## **Development Facilitation Team (DFT) – Review Comments**

**DRB Project No: PR-2022-007617 Date: 04/26/2023 Agenda Item: #5 Zone Atlas Page: H-21**  
**Legal Description: LOTS 4 & 5 BLOCK 90-A, SNOW HEIGHTS ADDITION**  
**Location: 11100 & 11200 TOWNER AVE NE between COLLET ST NE and JUAN TABO BLVD NE**

**Application For: SD-2023-00056 – PRELIMINARY/FINAL PLAT (DHO)**

**Sketch Plat for
 Lot 5-A, Block 90-A
 Snow Heights Addition
 Being Comprised of
 Lots 4 and 5, Block 90-A
 Snow Heights Addition
 City of Albuquerque
 Bernalillo County, New Mexico
 September 2022**

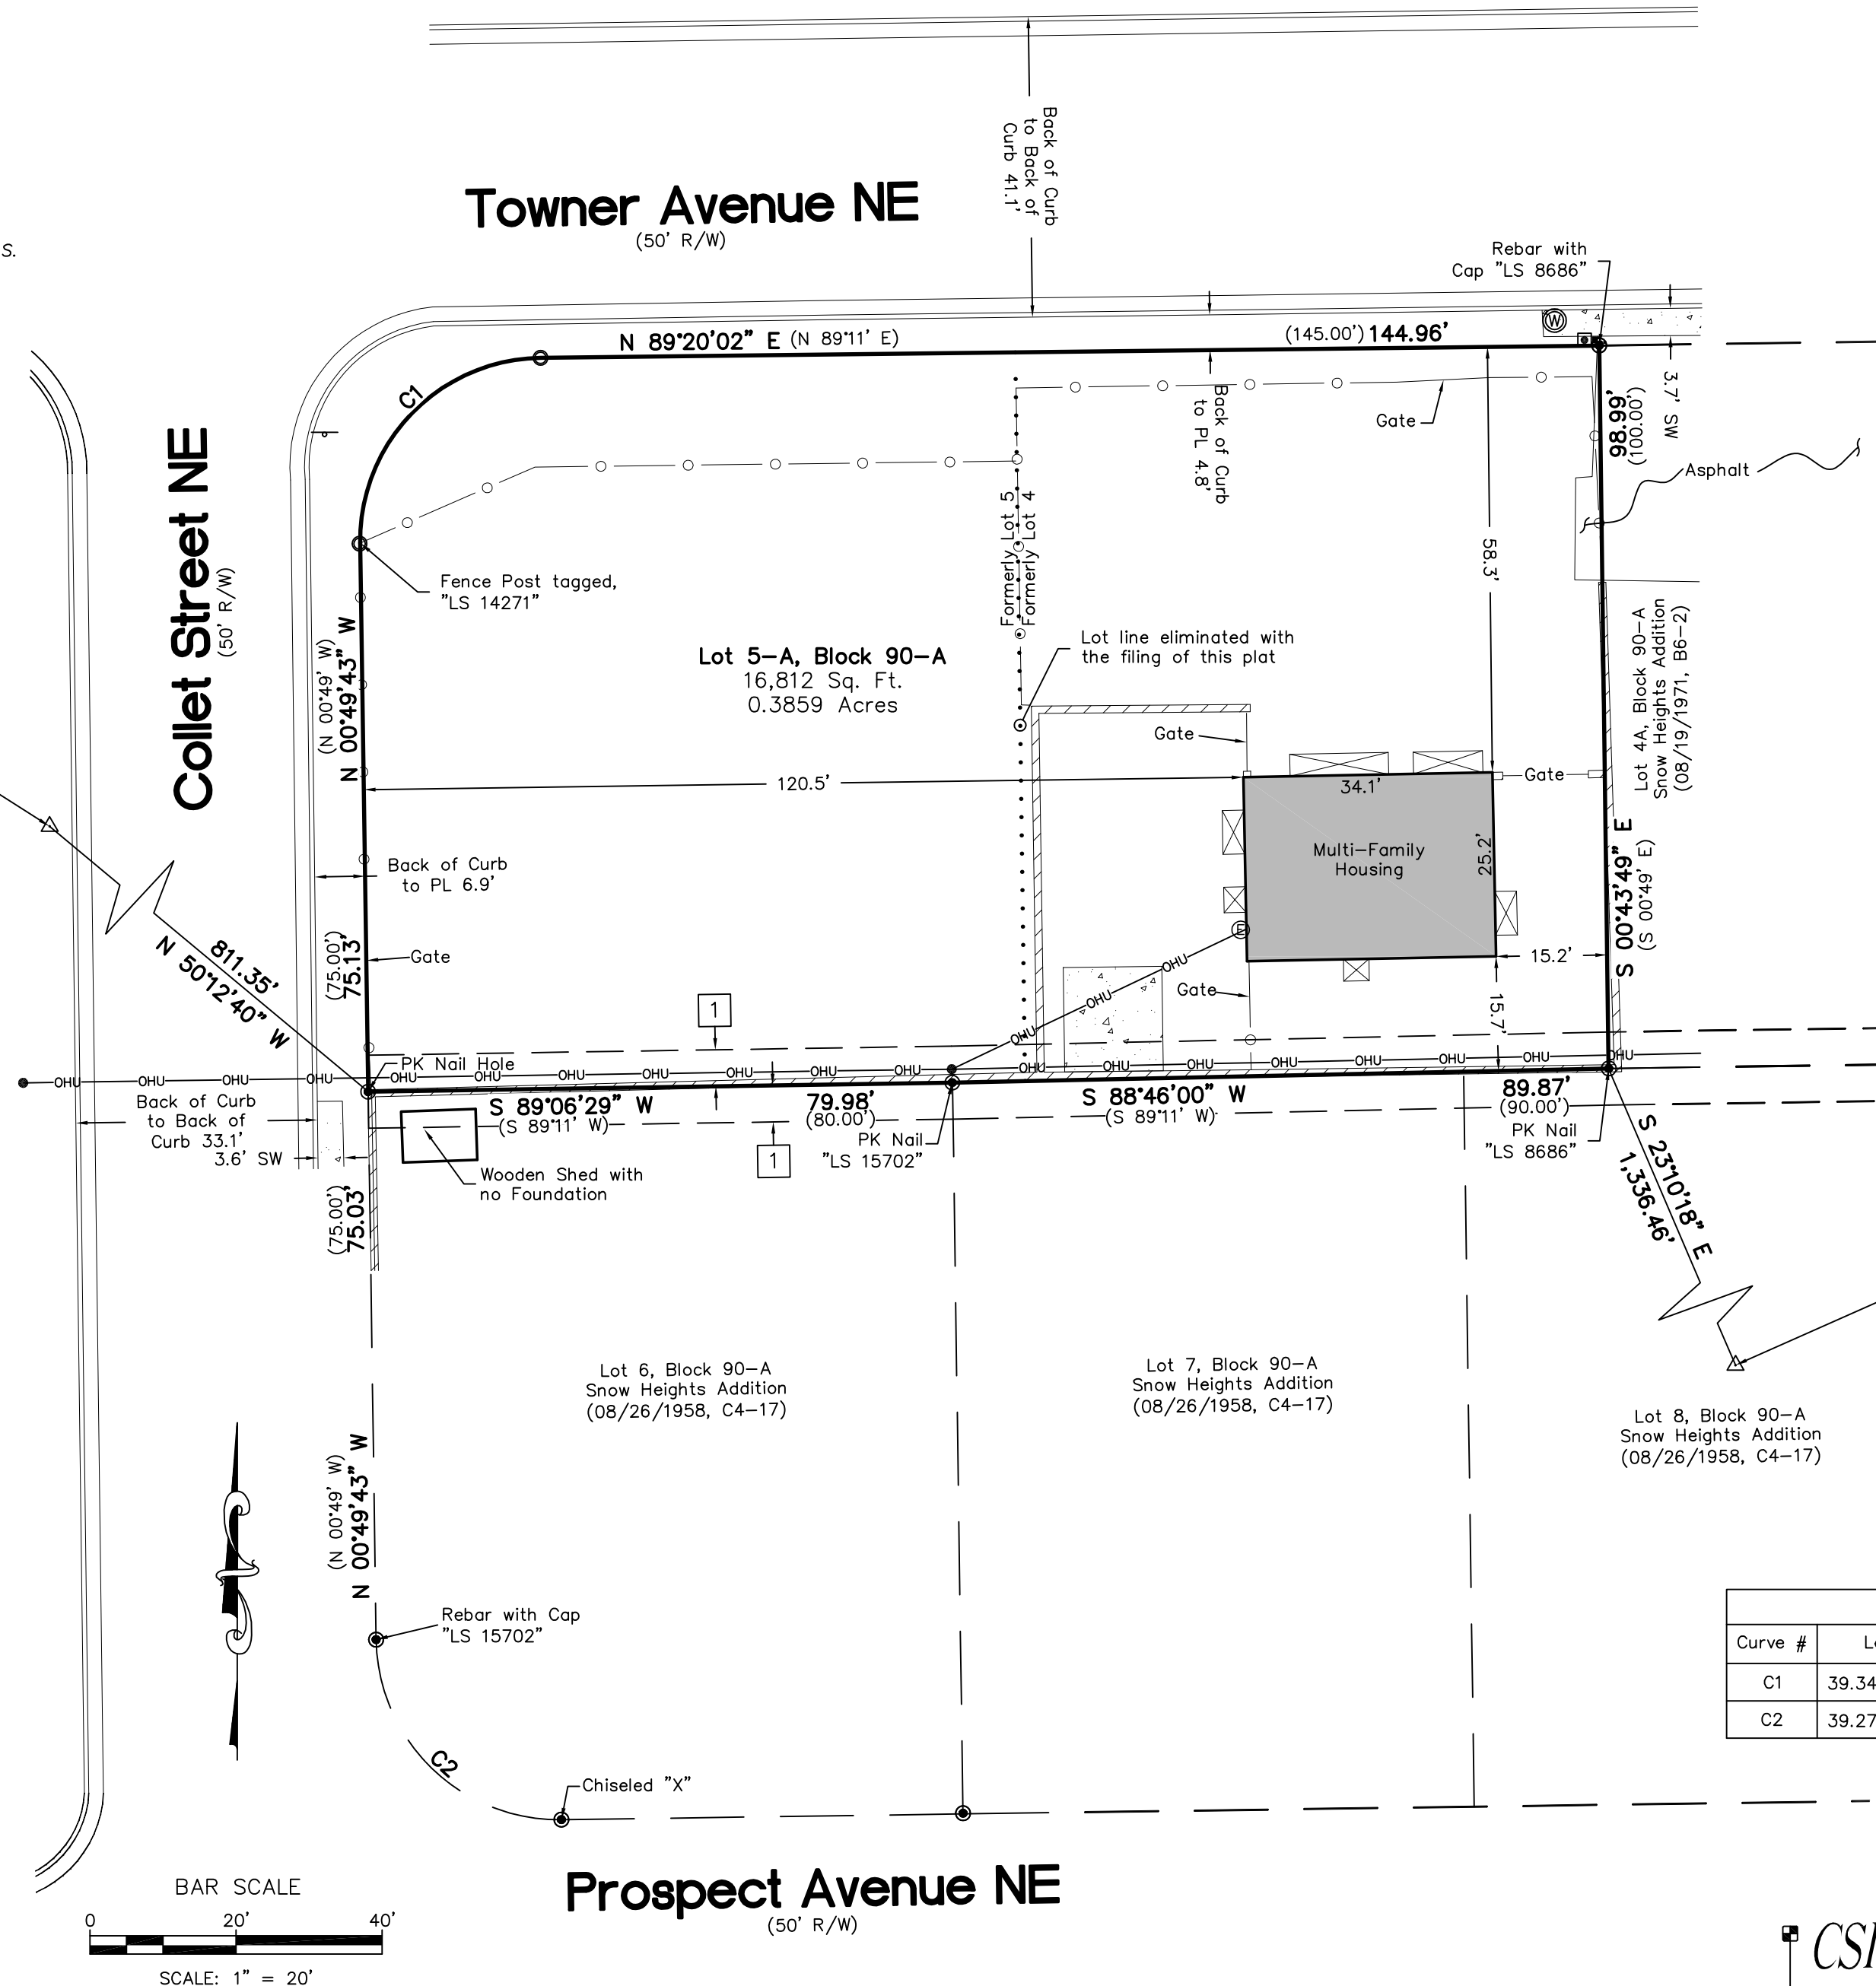
1. Plat has been corrected and addresses prior objection by Code Enforcement for width of lot.
2. Proposed development is for multi-family use, and is adjacent to an R-1B residential zone to the south. This would require a 15 ft landscape buffer on the southern property line, as per Table 5-6-4, IDO 5-6(E)(2)(a).
3. Proposed development must meet requirements of IDO 5-9, limiting to 30 ft height within 100 ft of southern property line for R-1B zone.
4. Code Enforcement has no further comments at this time, and no objections to proposed re-plat action.

- The project & application number must be added to the Plat prior to final sign-off by DFT staff, should the Plat be approved by the DHO.
- *Per Table 7.2.29 from section 7 of the DPM:*  
Towner and Collett are Local Streets. Require a 5ft Sidewalk & 4-6ft landscape buffer.  
*\*Please confirm compliance, or any waiver - DHO determination requests?*
- IL-infrastructure is showing 5ft sidewalks. Once the IL is approved, the project will need to provide a financial guarantee to DRC.
- Development clarification – Please confirm the future development of Multi-Family mentioned previously.  
**Multi-Family project will need to meet the Landscape buffer requirement per 5-6. Multi-Family next to low density residential. It will also need to meet the standards of Neighborhood edges, 5-9 which has a height limit of 30ft.**
